University of Sydney
Engineering and Technology precinct

DRAFT BCA Assessment Report

Report 2016 / 2529 R1.3

Prepared for the University of Sydney
February 2018

Project
THE UNIVERSITY OF SYDNEY ETP STAGE 1
Electrical Engineering Building
University in Darlingtown, NSW 2008
Drawing Title
FLOOR PLAN - LEVEL 02

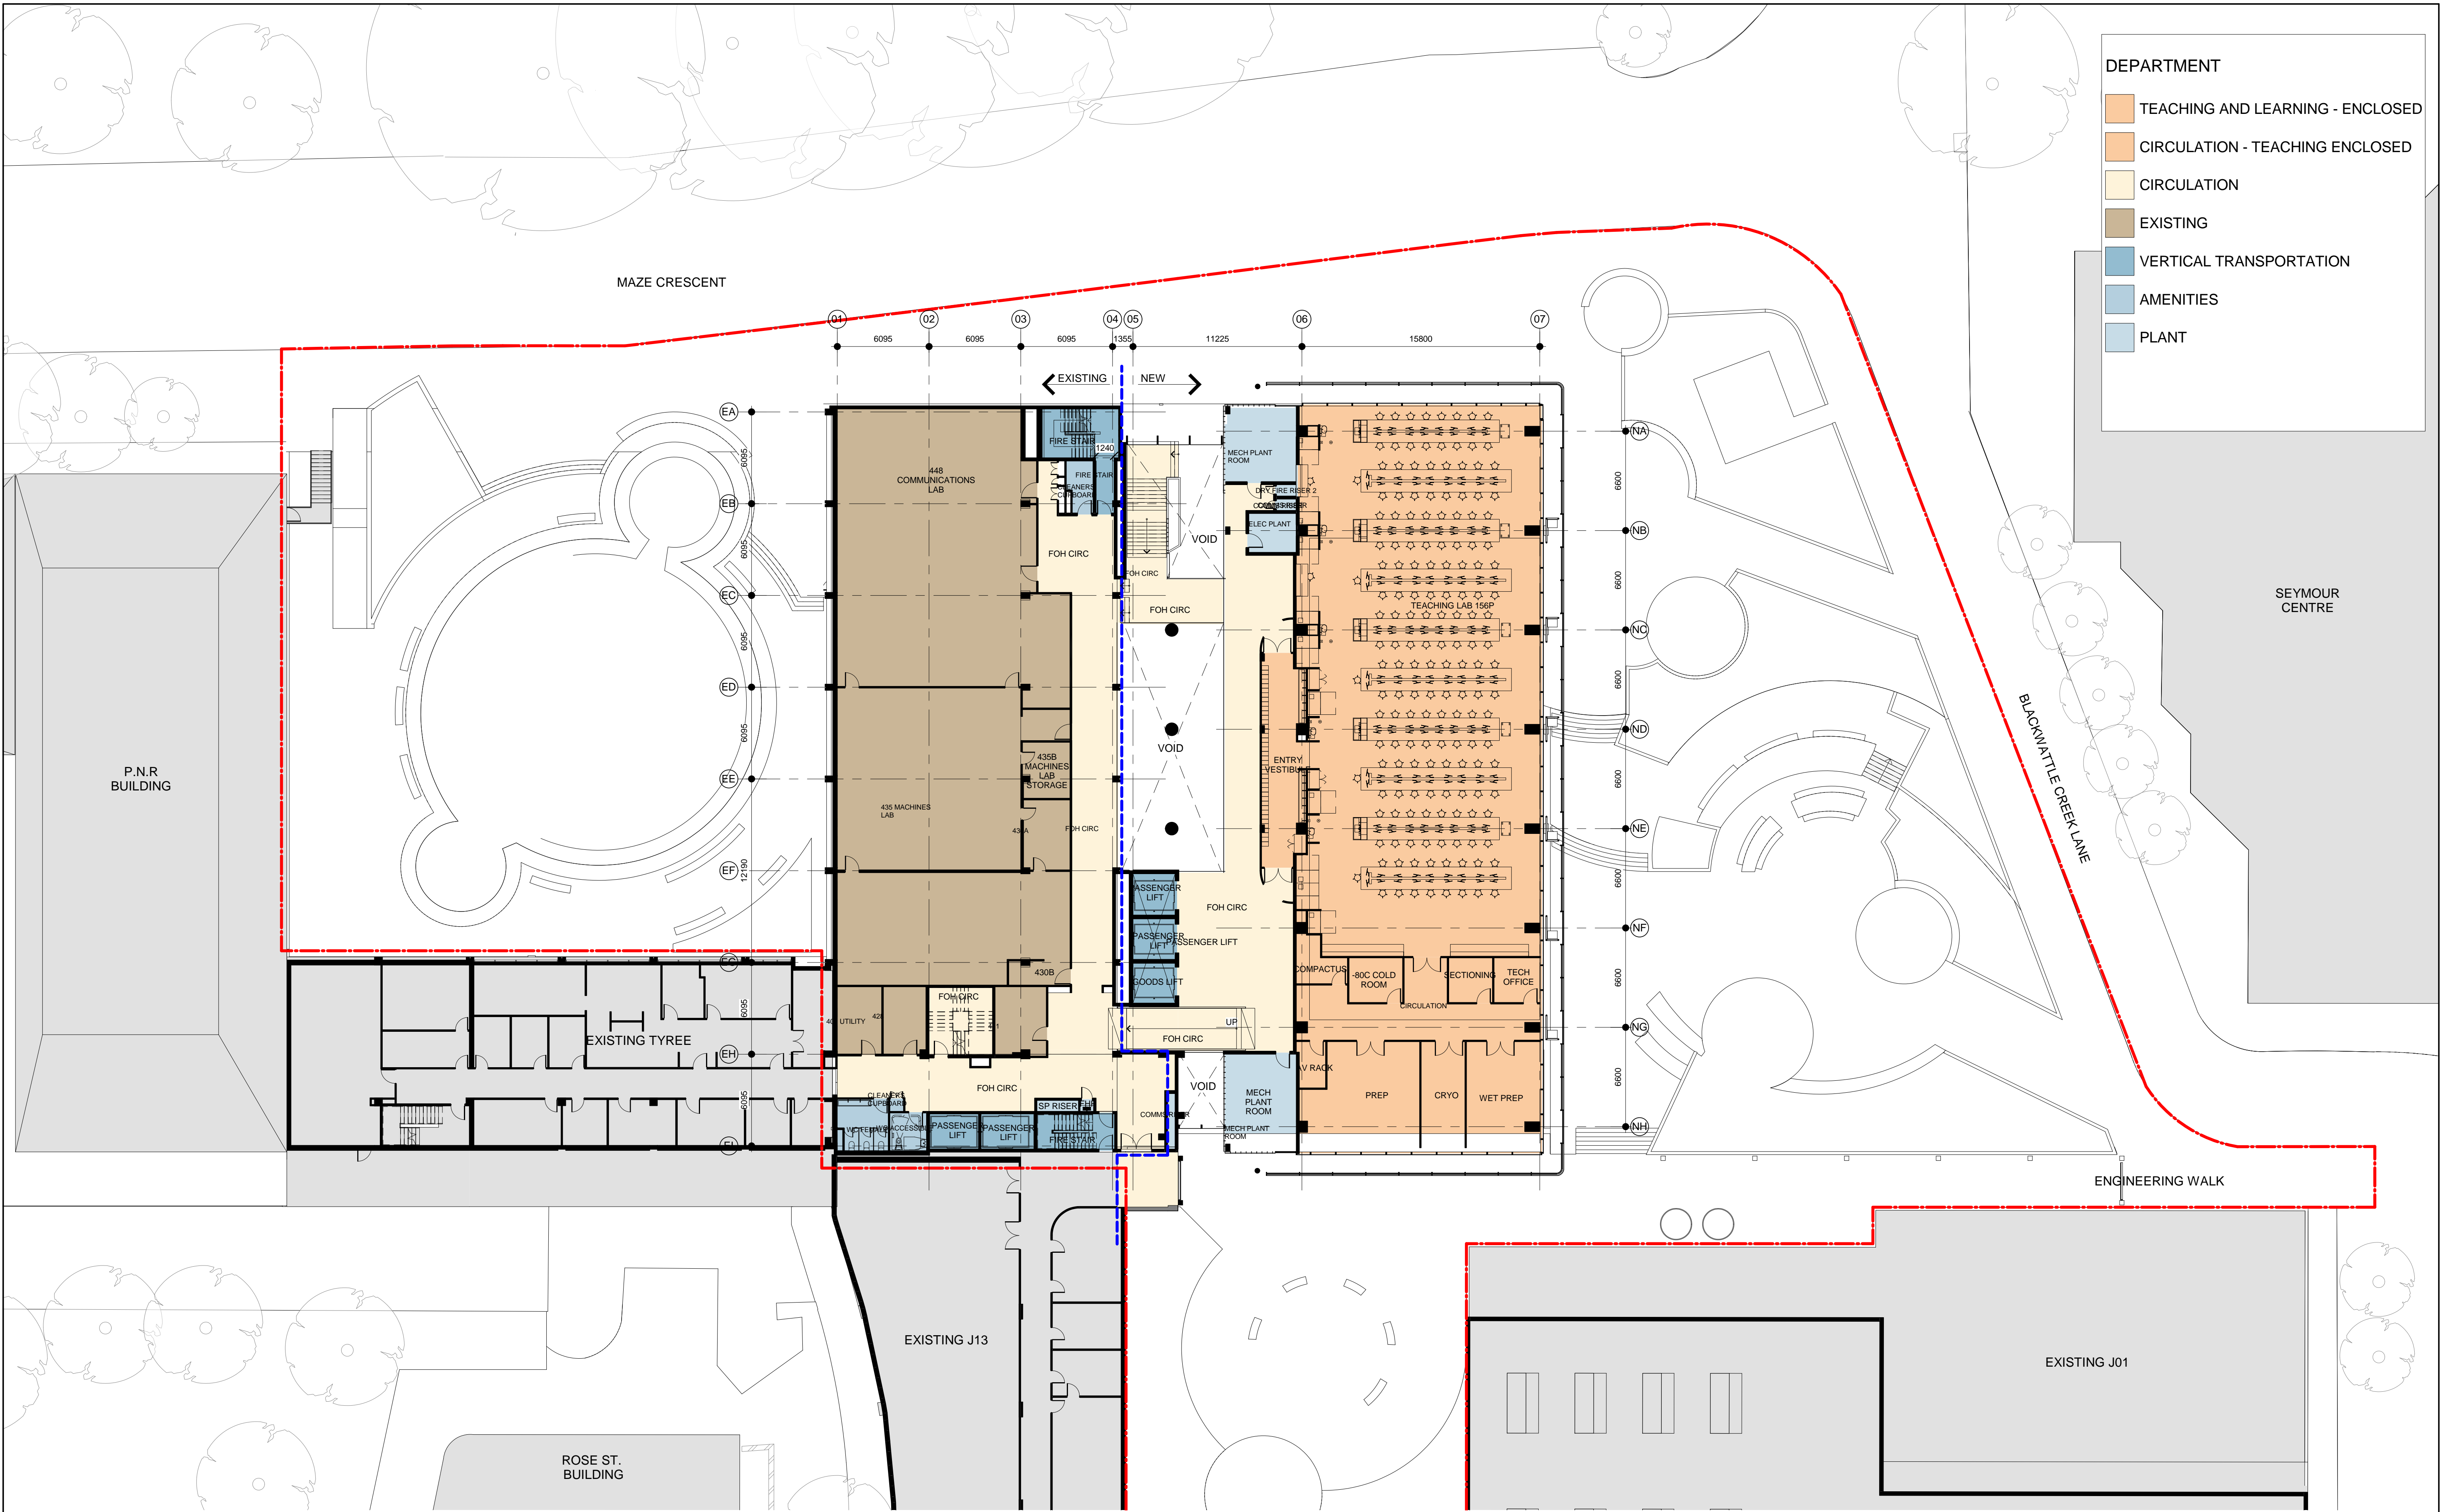
Item	DTS Clause	Description of Non-compliance	Requirement to Satisfy BCA
1.	D1.4	Exit travel distances	Access to and location of the following exits needs to be re-designed: <ul style="list-style-type: none">▪ L1 research lab over 33 m▪ L2 teaching lab over 30 m▪ Typical level teaching labs over 35 m
2.	D1.6	In sufficient egress width is provided for the proposed population	The door to the western stair must be widened.
3.	D1.7	The eastern stair discharges to a space that is not sufficiently open and exposed to adjacent openings	Protect opening as required
